Response to Highways England Deadline 2 Documents 8.20, 8.23, 8.25 & 8.26:

HE Document: 8.20 Statement of Common Ground with Birmingham Airport Ltd

HE Document: 8.23 Lighting Technical Note

Figure M.2: Ecological Features and Airfield Safeguarding Areas Plan

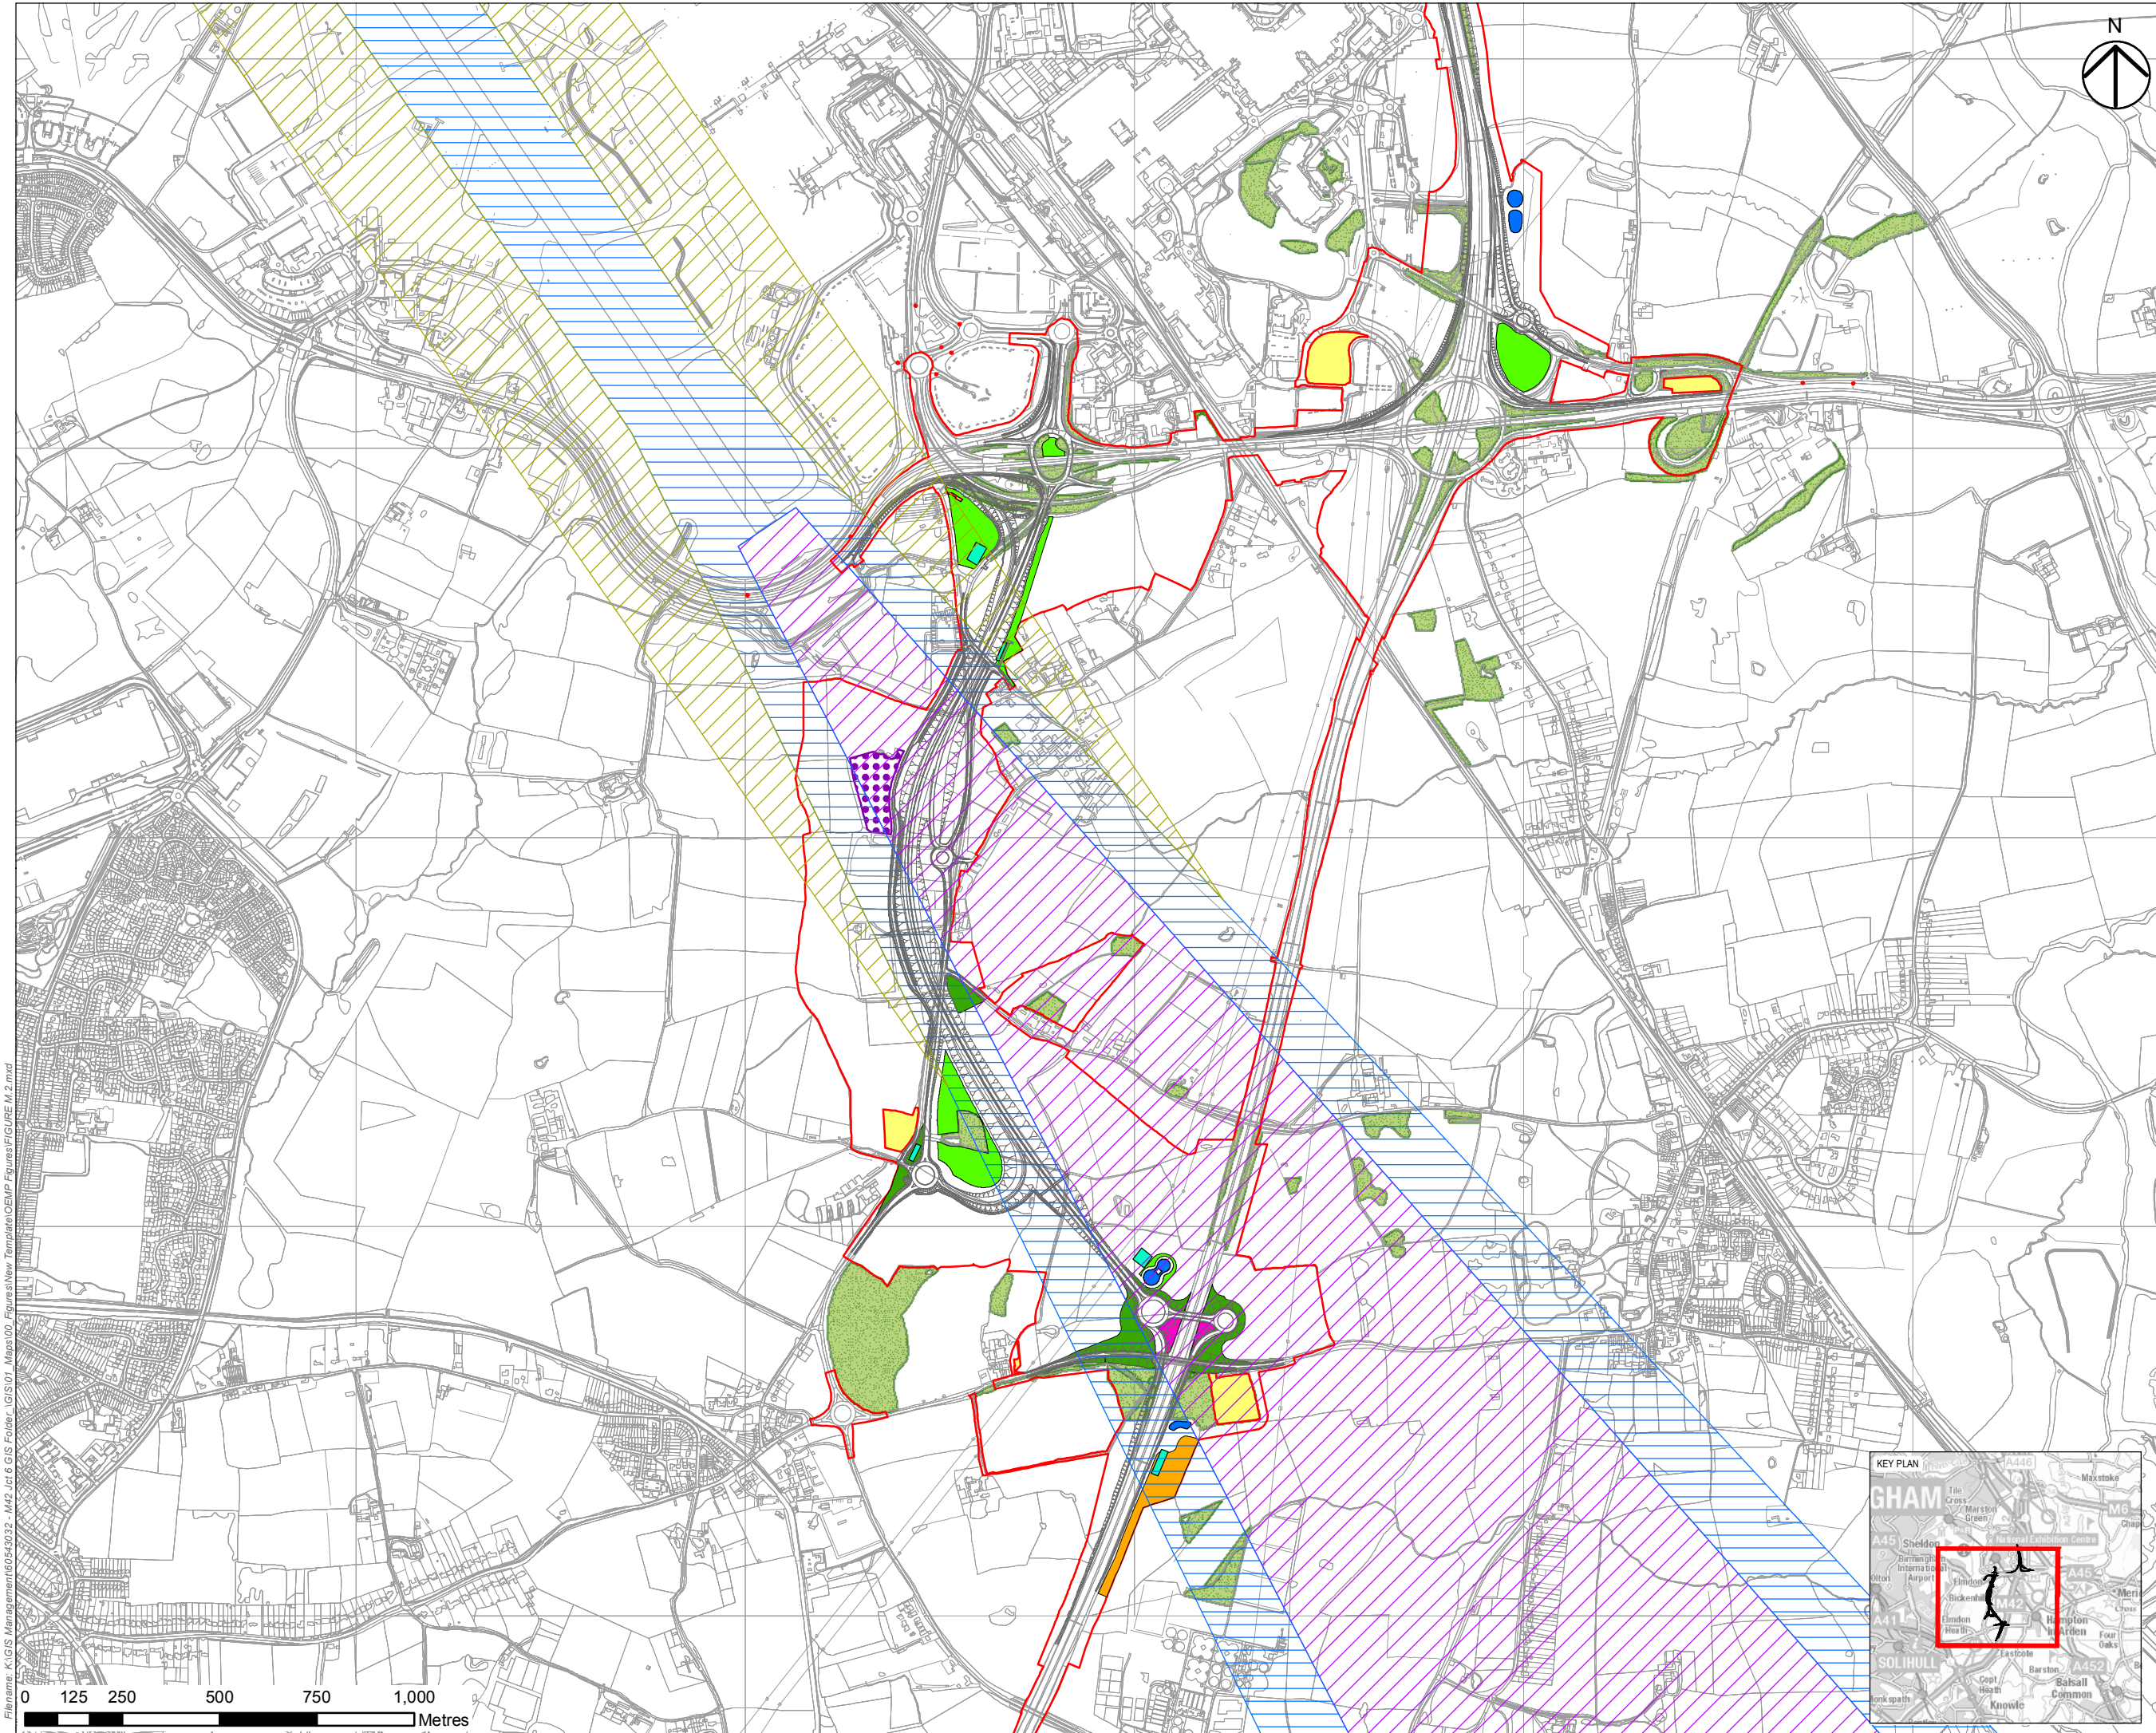
Figure M.2: Ecological Features and Airfield Safeguarding Areas Plan which is provided in the HE Document: 8.25 Outline Bird Strike Management Plan indicates the safeguarding areas for Birmingham Airport and confirms that Four Winds is outside the safeguarding area. Andrew Davies (BIA Safeguarding) confirmed in the meeting of 28th February 2018 that Birmingham Airport would not have an issue with the planting of trees outside the airport surface. As such there are no reasonable grounds for HE to dismiss my suggestion to plant out the field around my property to not only mitigate the impact of the reconfigured WGAA on my property but to also mitigate the loss of natural habitat resulting from their scheme.

Contrary to information previously provided by Highways England, this document confirms my property and the majority of the adjacent field are outside the Airport Safeguarding Area:

This drawing indicates the safeguarding areas for Birmingham Airport and confirms that Four Winds is outside the safeguarding area. Andrew Davies (BIA Safeguarding) confirmed in a meeting with Highways England on 28th February 2018 that Birmingham Airport would not have an issue with the planting of trees outside the airport surface. As such there are no reasonable grounds for HE to dismiss my suggestion to plant out the field around my property to not only mitigate the impact of the reconfigured WGAA on my property but to also mitigate the loss of natural habitat elsewhere resulting from their scheme. Can HE please confirm this matter will be given due consideration, and a full response provided, as it has previously been discussed with Jonathan Pizzey (HE)?

As such there are no reasonable grounds for HE to dismiss my suggestion to plant out the field around my property to not only mitigate the impact of the reconfigured WGAA on my property but to also mitigate the loss of natural habitat resulting from their scheme.
